Our Ref: AW/123/18/HH
Your Ref:

Town & Country Planning Act 1990 (as amended)
Town & country Planning (Development Management Procedure) (England) Order 2015
Application for Planning Permission for Works or Extension to a Dwelling

Development Demolition of conservatory, replacement with single storey rear extension & 2 No. rooflights to the north elevation.
Location 9 Copthorne Way Aldwick

CLIENT'S NAME Mr & Mrs Cripp	DRAWING TITLE Site & Block Plan	SCALE 1:500/200@A4	DATE 04/18
		STATUS PLANNING	
JOB TITLE 9 Copthorne Way Bognor Regis	DRAWN SCB	JOB NO 013	DRAWING NO PL-02
			REV A

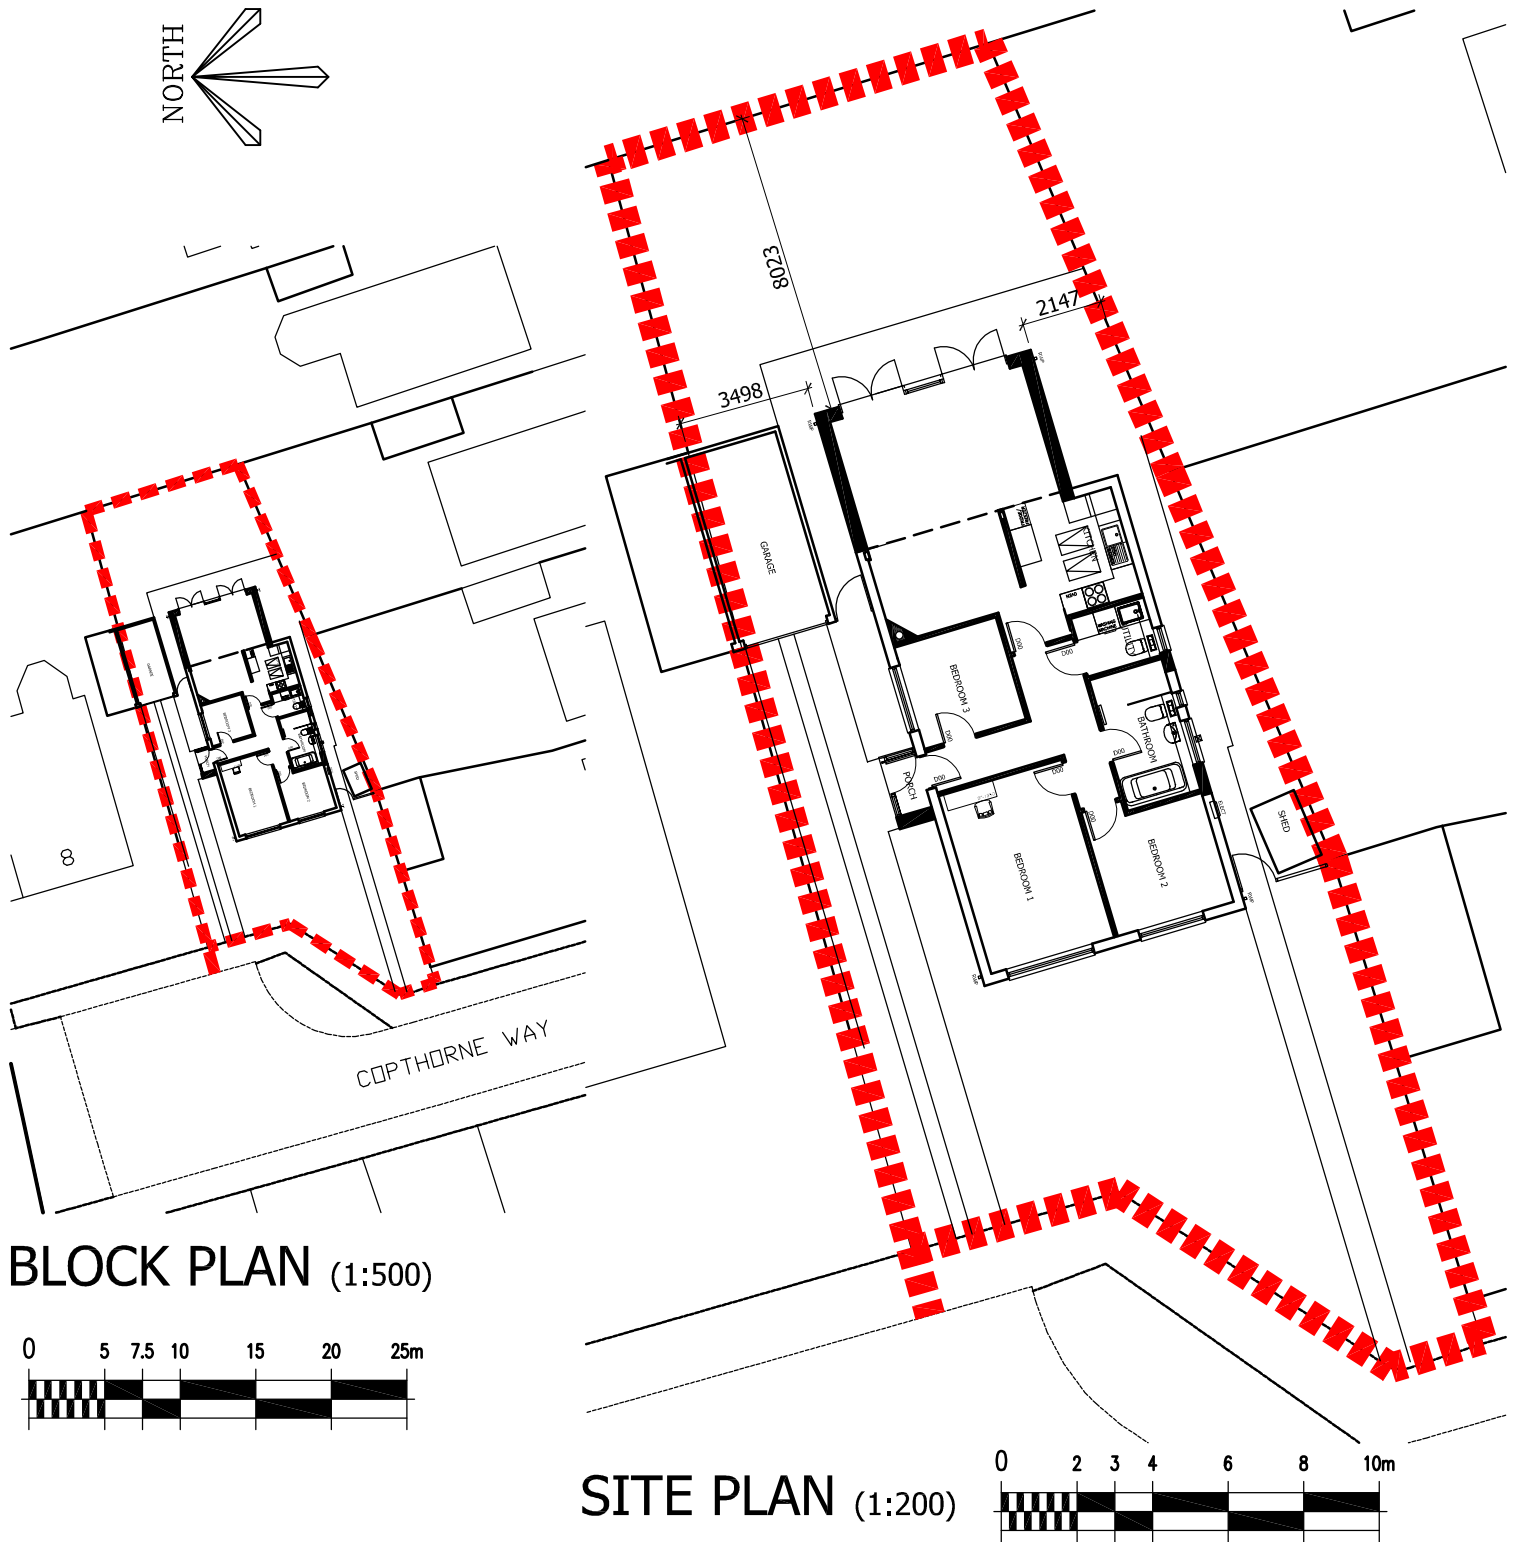
Block Plan Amend

Please submit 1 electronic or 3 paper copies of a block/site plan at a scale of 1:500 or 1:200. Further details of what must be included on the plan can be found in the National Validation Requirements. Please provide measurements from the proposal to the site boundaries.

SCALE 1:50
JOB NO 013
STATUS
DATE 04/18
REV PL-03
REV A
DRAWN SCB

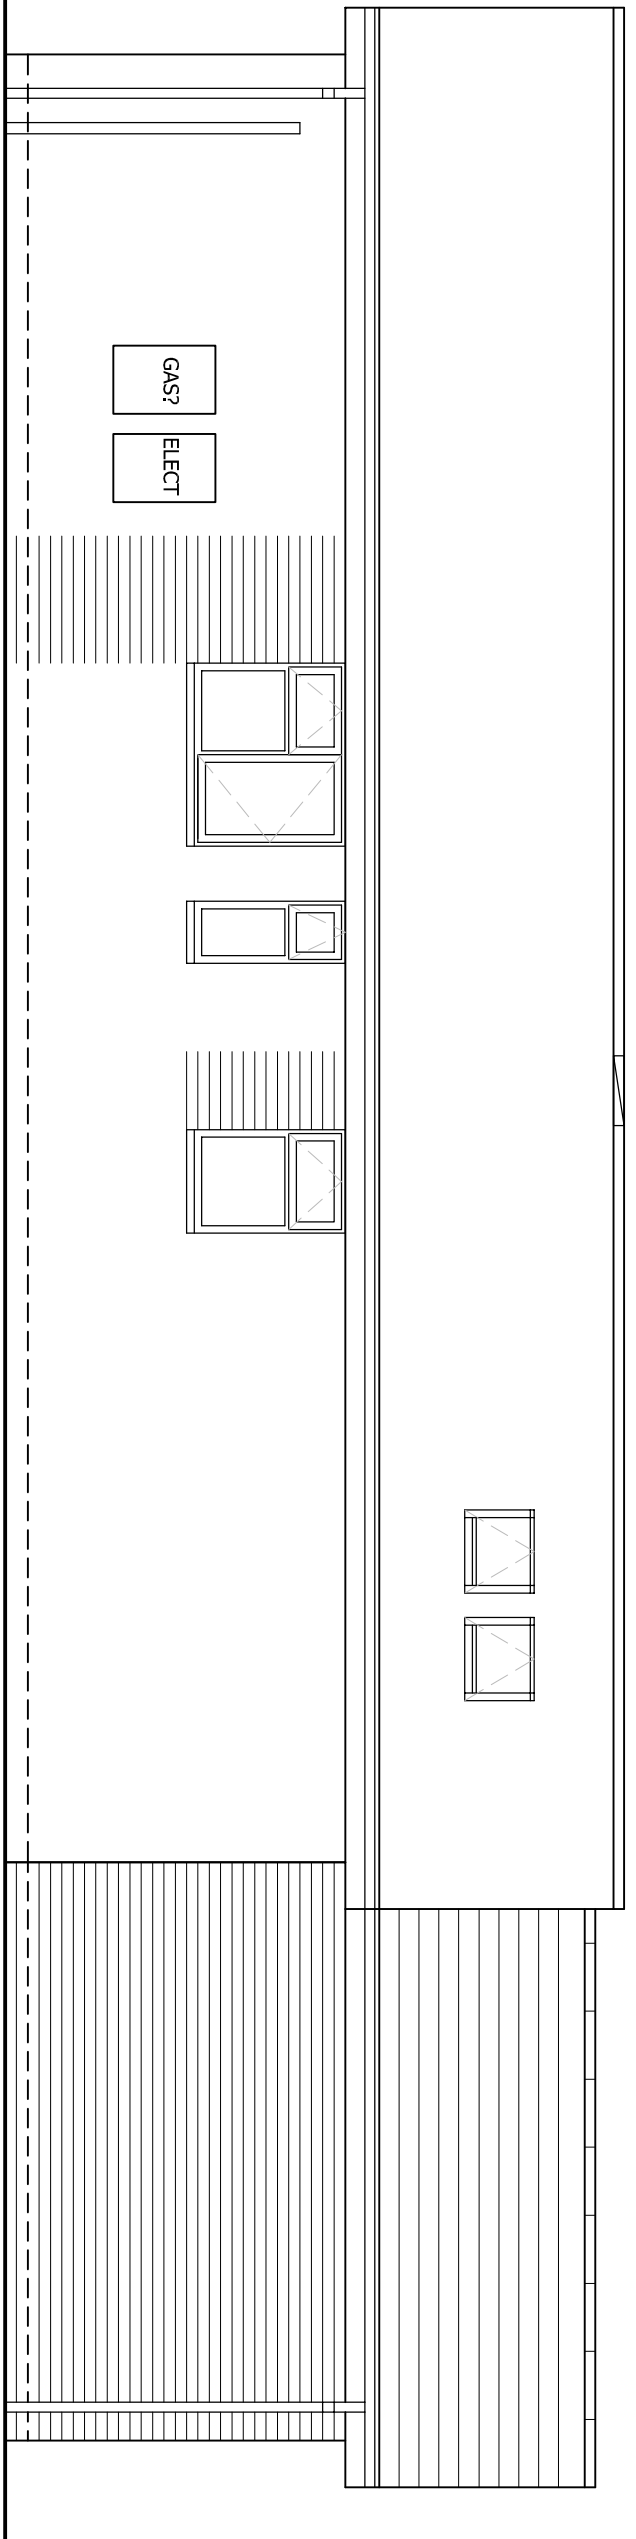
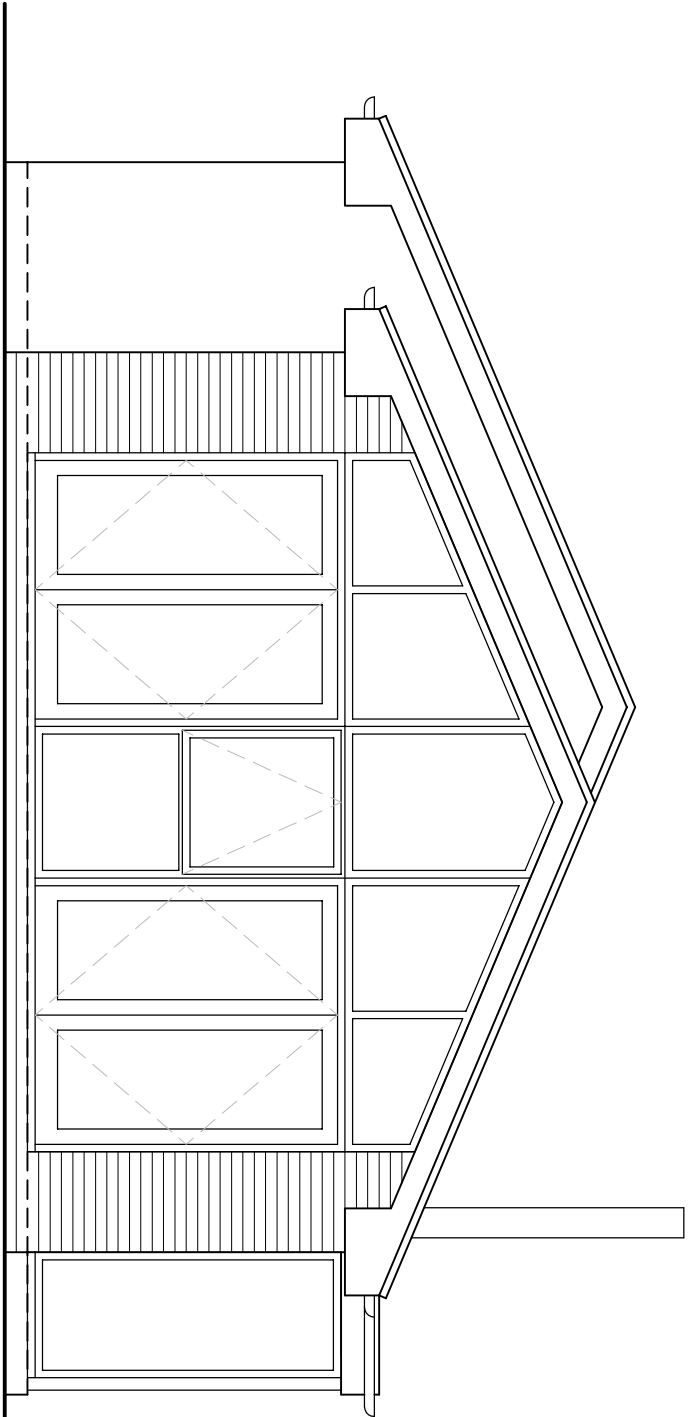
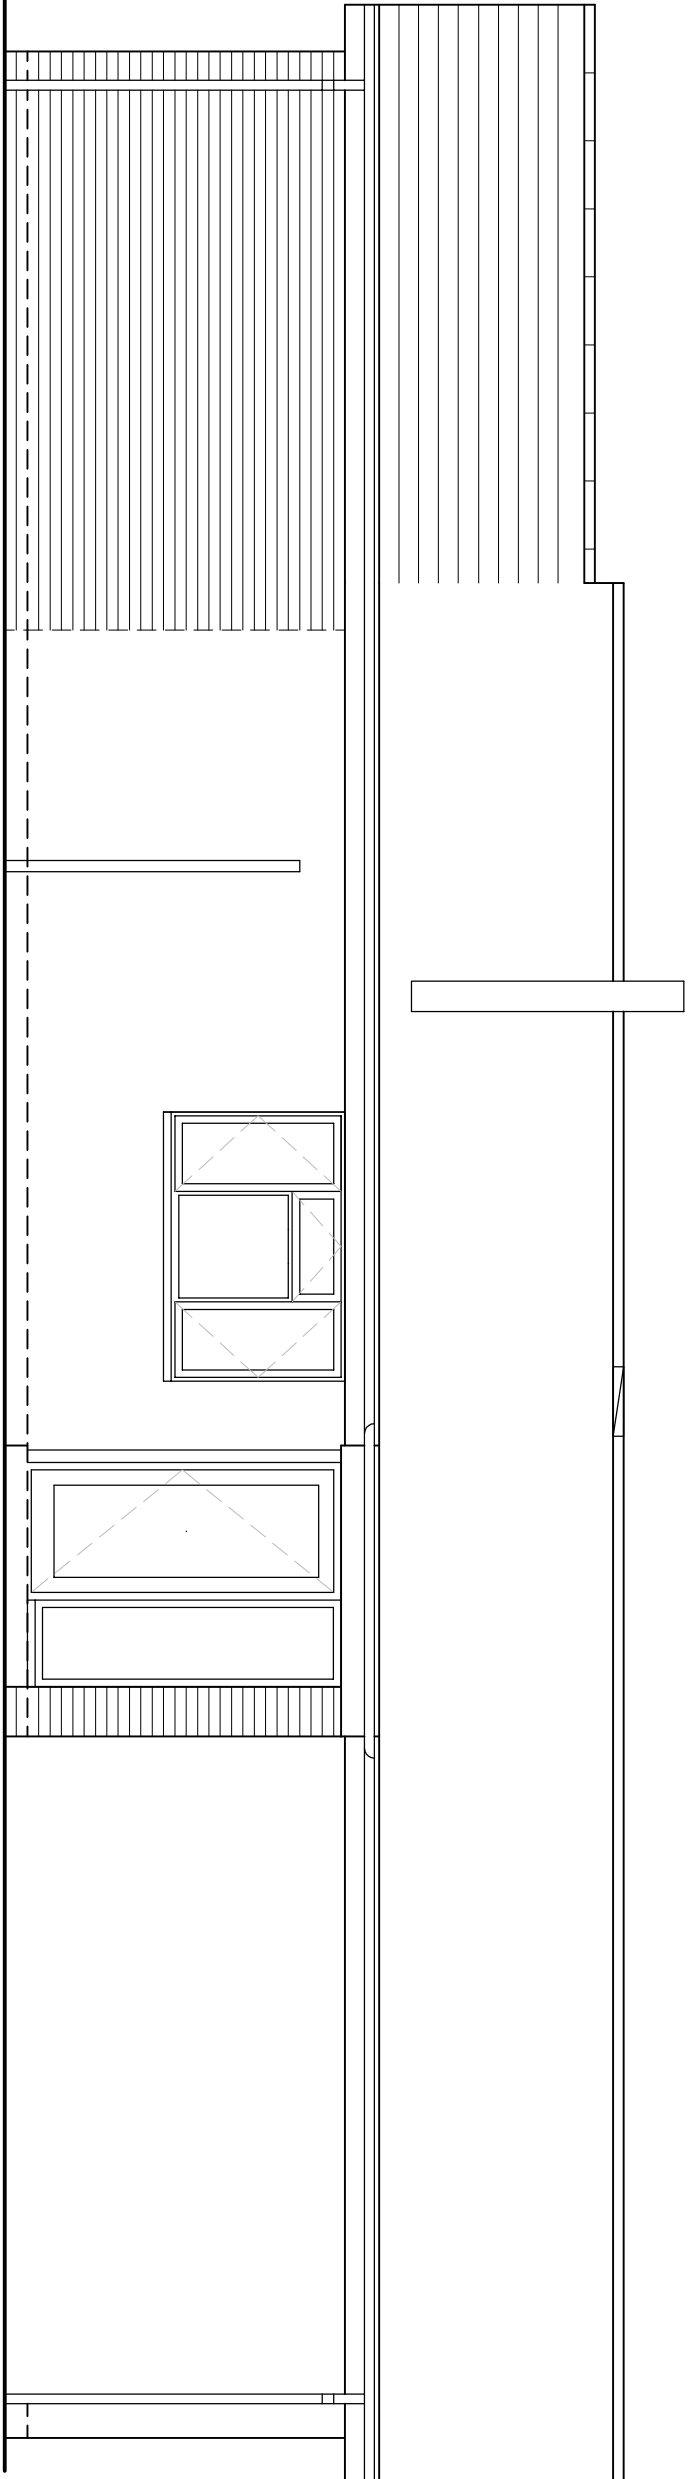
The existing and proposed East and West elevations have been labelled incorrectly. Please amend accordingly.
